Your ref: SSD 8981  
Our ref: (0035/19DA)

## **Coffs Harbour Hospital Expansion, 345 Pacific Highway, Coffs Harbour (SSD 8981) – Notice of Exhibition**

Council has reviewed the proposal and wishes to make comment in relation to the following matters:

Figure 7.2 Overall MUSIC Model Results (Bonacci 2018)

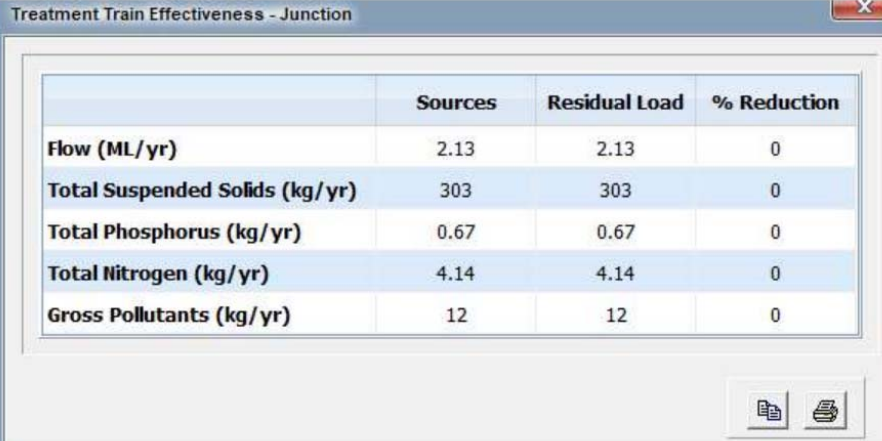
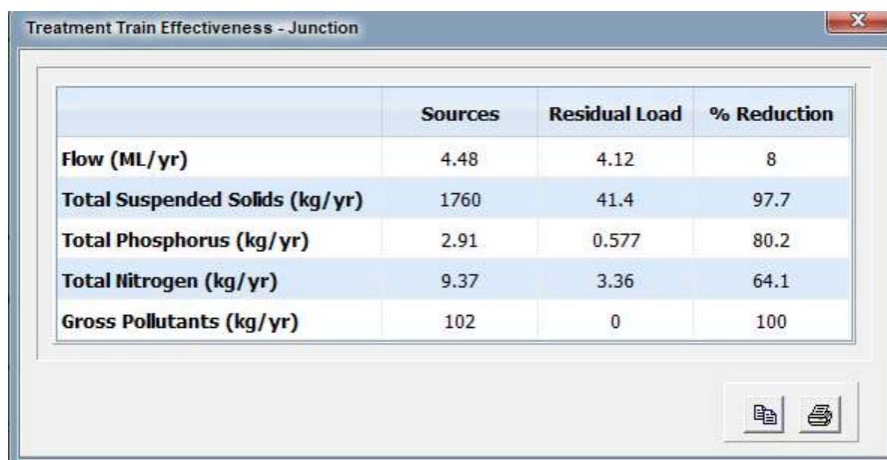
- With regard to the water quality component of the stormwater management plan, the plan fails to meet all of Council's pollutant reduction objectives – specifically Total Nitrogen – the report indicates the overall reduction is only 30%, which falls significantly short of the 45% reduction target.
- The report notes a neutral or beneficial (NorBE) effect is achieved, however, this is not necessarily considered an adequate outcome for redevelopment where it generally translates to 'business as usual' or a slight improvement. The objective of Council's WSUD

Another concern is the proposed bioretention swale. Council has no concerns with implementing a bioretention swale, the concern is that the drawings (eg CV-CSB-01133 Rev 03 Sheet 3) indicate that it is just a "Swale Drain" (i.e. no bioretention filter and underdrainage), which will not achieve the same treatment objectives that were modelled with MUSIC.

- additional treatment needs to be provided to achieve the pollutant reduction objectives in Council's WSUD guidelines; and
- the submitted drawings need to clearly indicate the detail for a bioretention swale (filter area and underdrainage), where is intended along western side of new carpark.
